# CITY OF ALBUQUERQUE

May 6, 2019

**Re: Orpheum Community Hub,  
500 2<sup>nd</sup> St SW  
Request for Certificate of Occupancy  
Transportation Development Final Inspection  
Engineer's/Architect's Stamp dated 10-08-18 (K14D114)  
Certification dated 4-25-19**

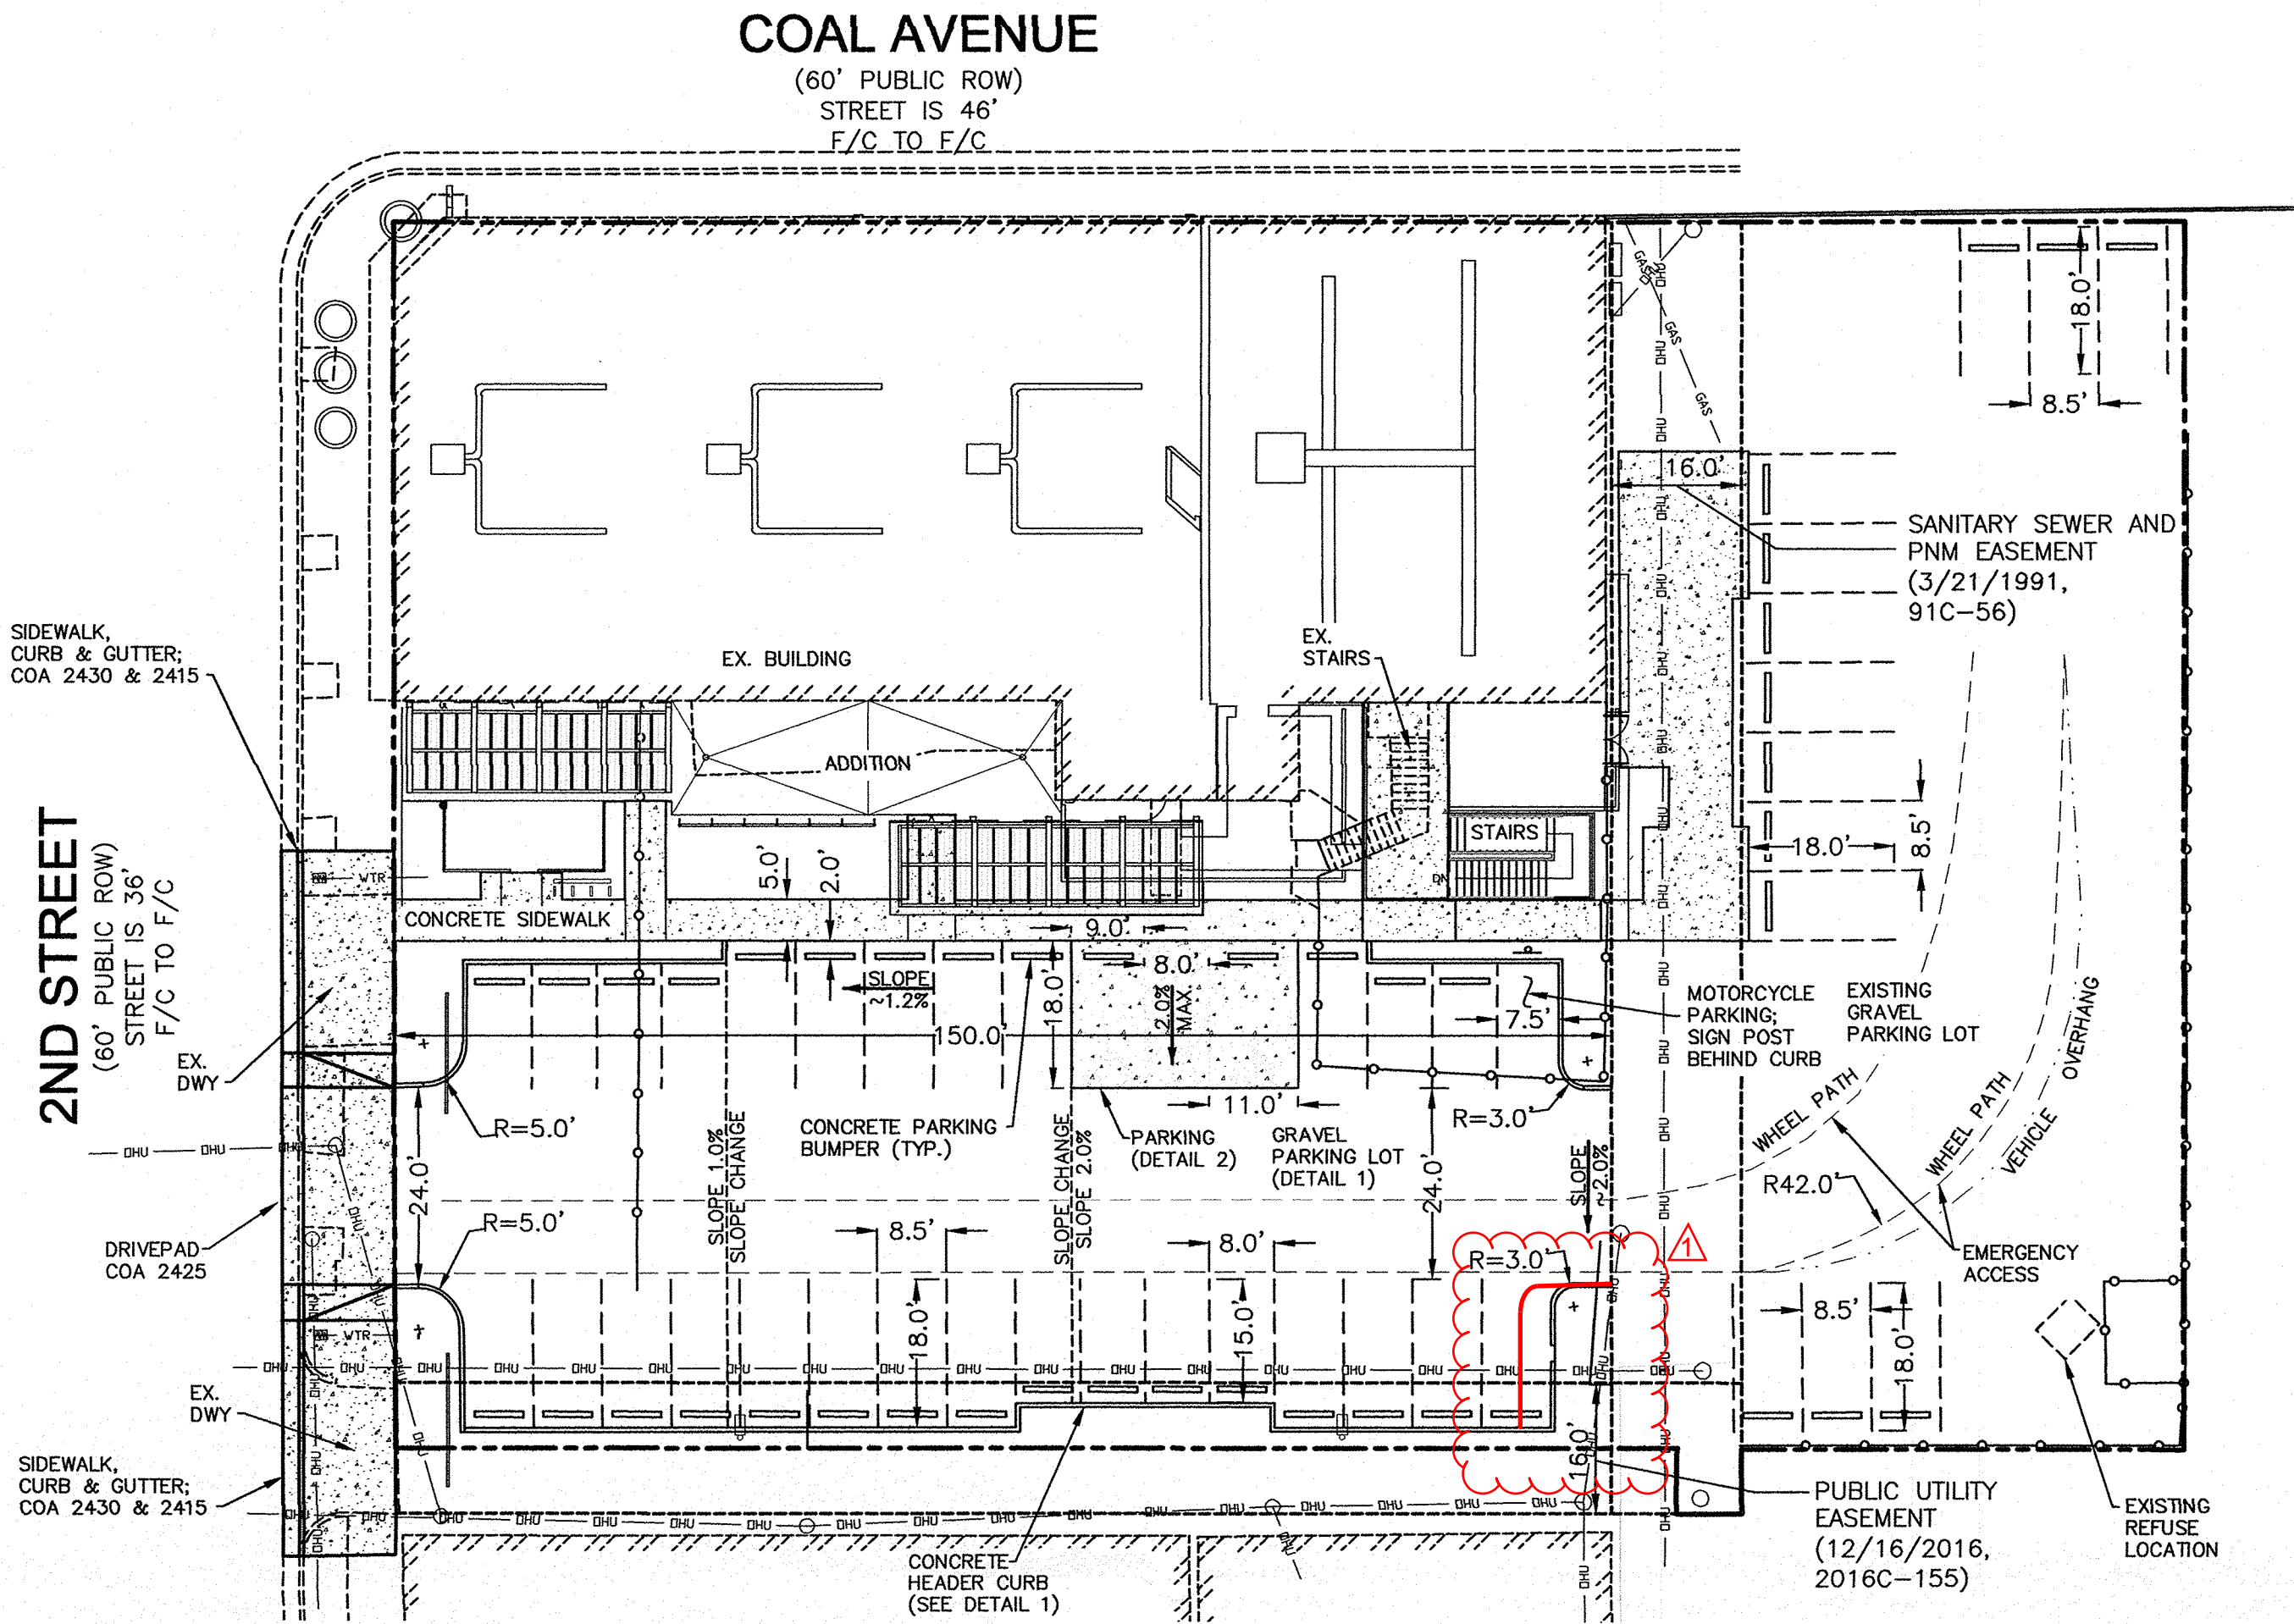
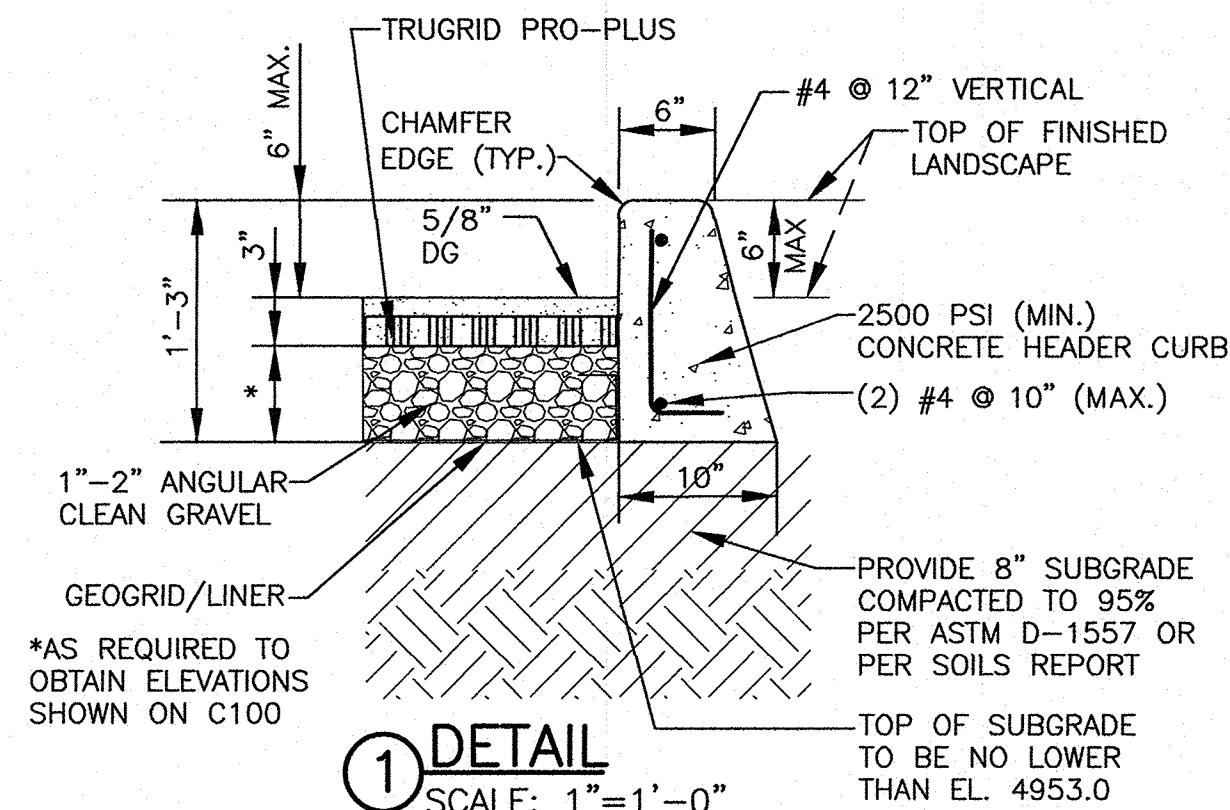
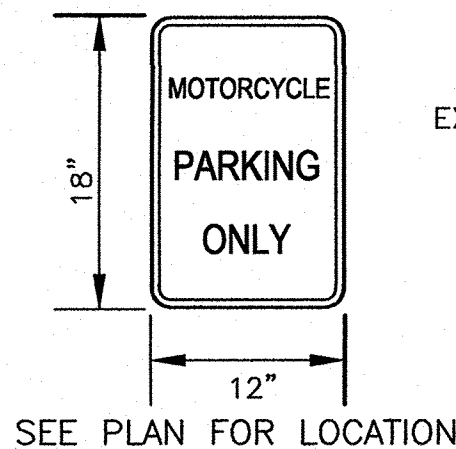
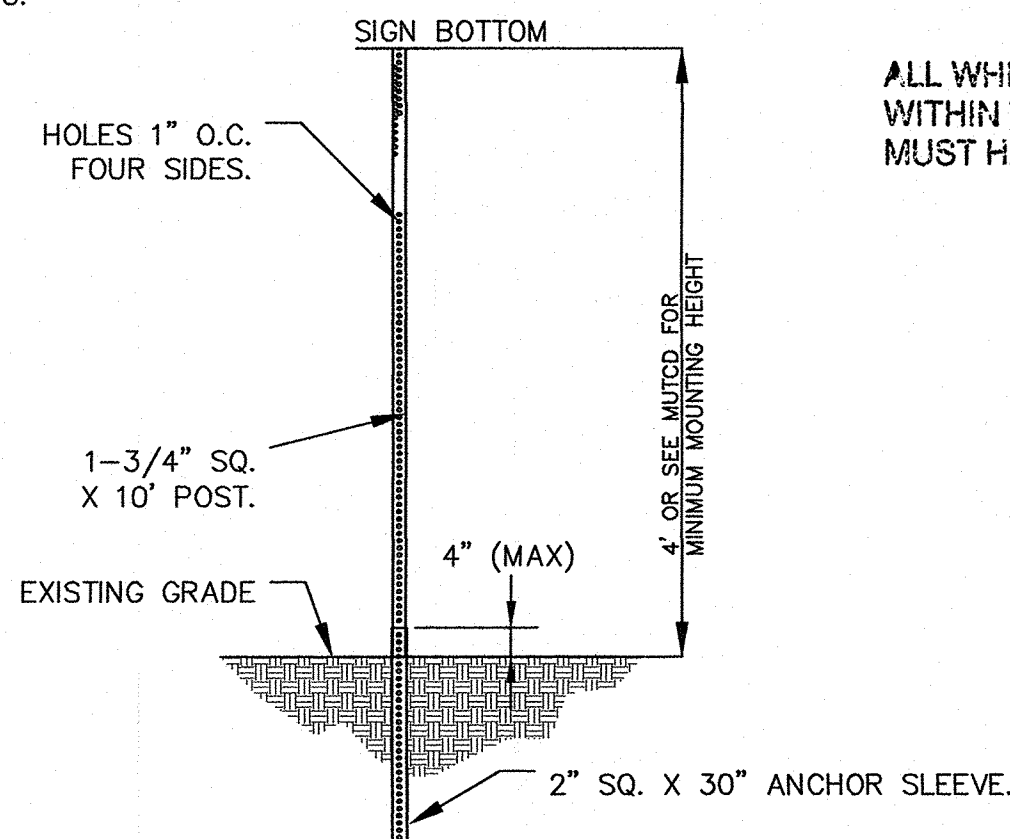
- There was still construction going on in parking lot.
- Please add Motorcycle and ADA parking stall signs.
- Please add ADA floor markings to parking stalls and access aisle.
- Please add missing wheel stops.
- Please remove construction debris and equipment.
